From: Sue Howell
Sent: 09 September 2019 15:19
To: Planning.Responses <Planning.Responses@arun.gov.uk>
Cc: Michael Eastham <Michael.Eastham@arun.gov.uk>
Subject: RE: Planning Consultation on: WA/90/19/DOC

APPLICATION NO: WA/90/19/DOC

Site Address: Land East of Tye Lane Walberton

Description of Works: Application for approval of details reserved by condition imposed on planning ref WA/95/18/RES relating to condition 2 - tennis courts

TLTC-01

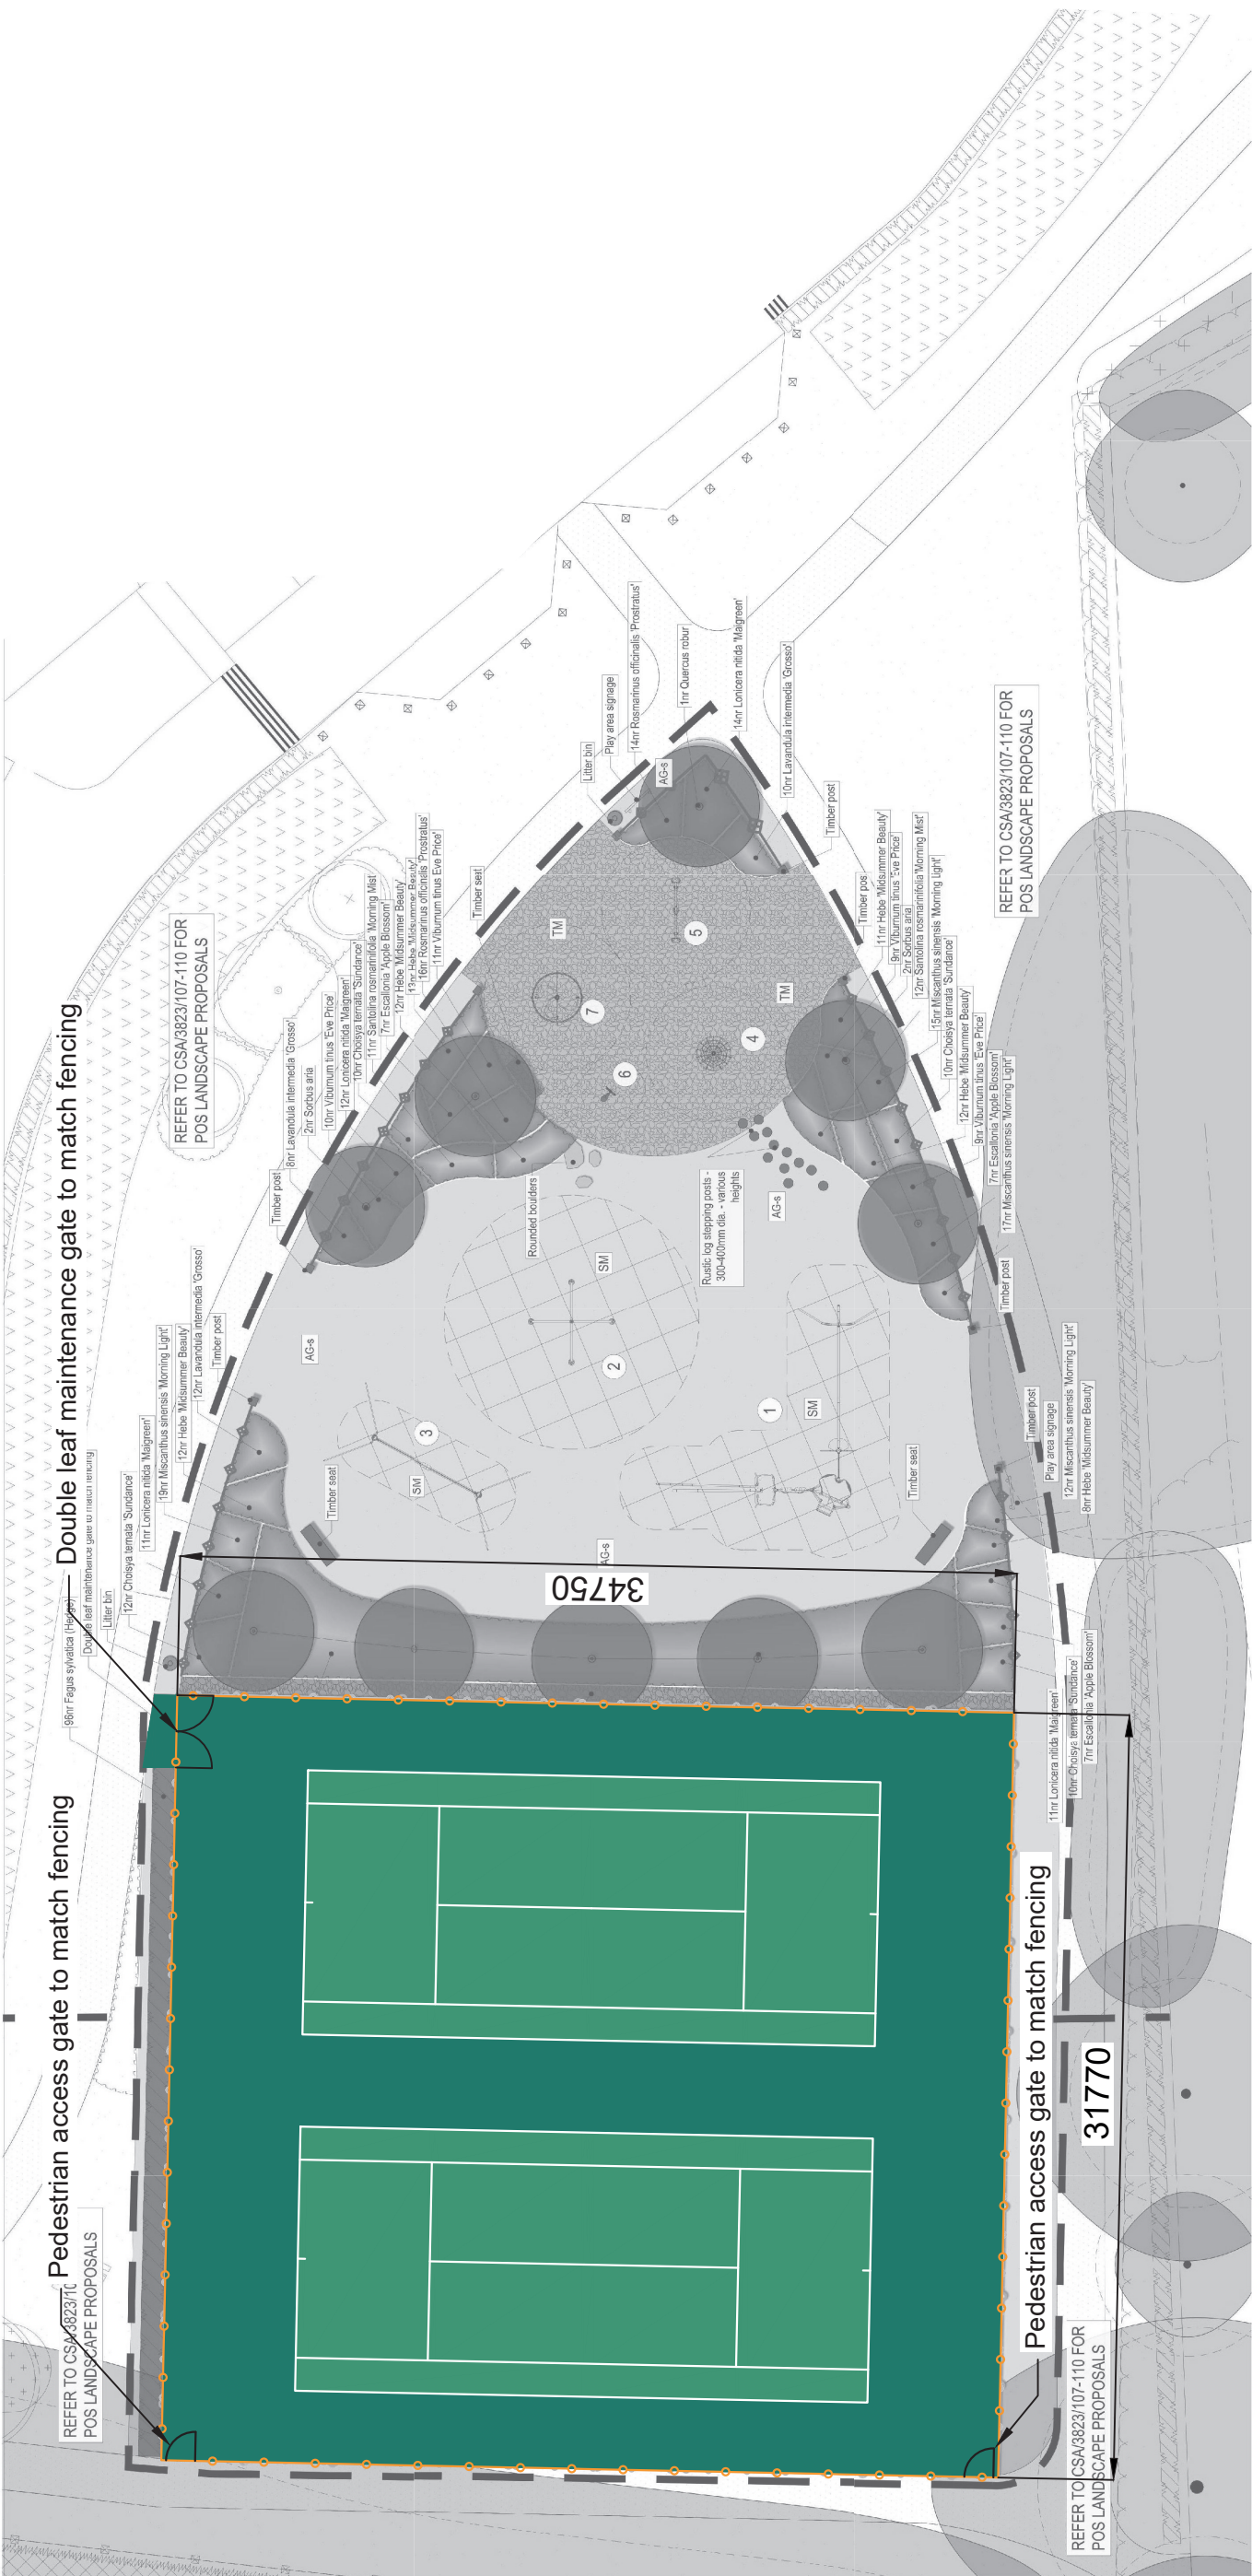
Further to submission of details contained in General Arrangement Dwg TLTC-01 and Dwg TLTC-02, I can confirm that the submission provides information of the construction of the proposed tennis courts, detail of their design and specification including cross-section of construction and sub-base.

I would therefore **advise to recommend the discharge of Condition 2** on this application WA/90/19/DOC, imposed under planning approval WA/95/18/RES.
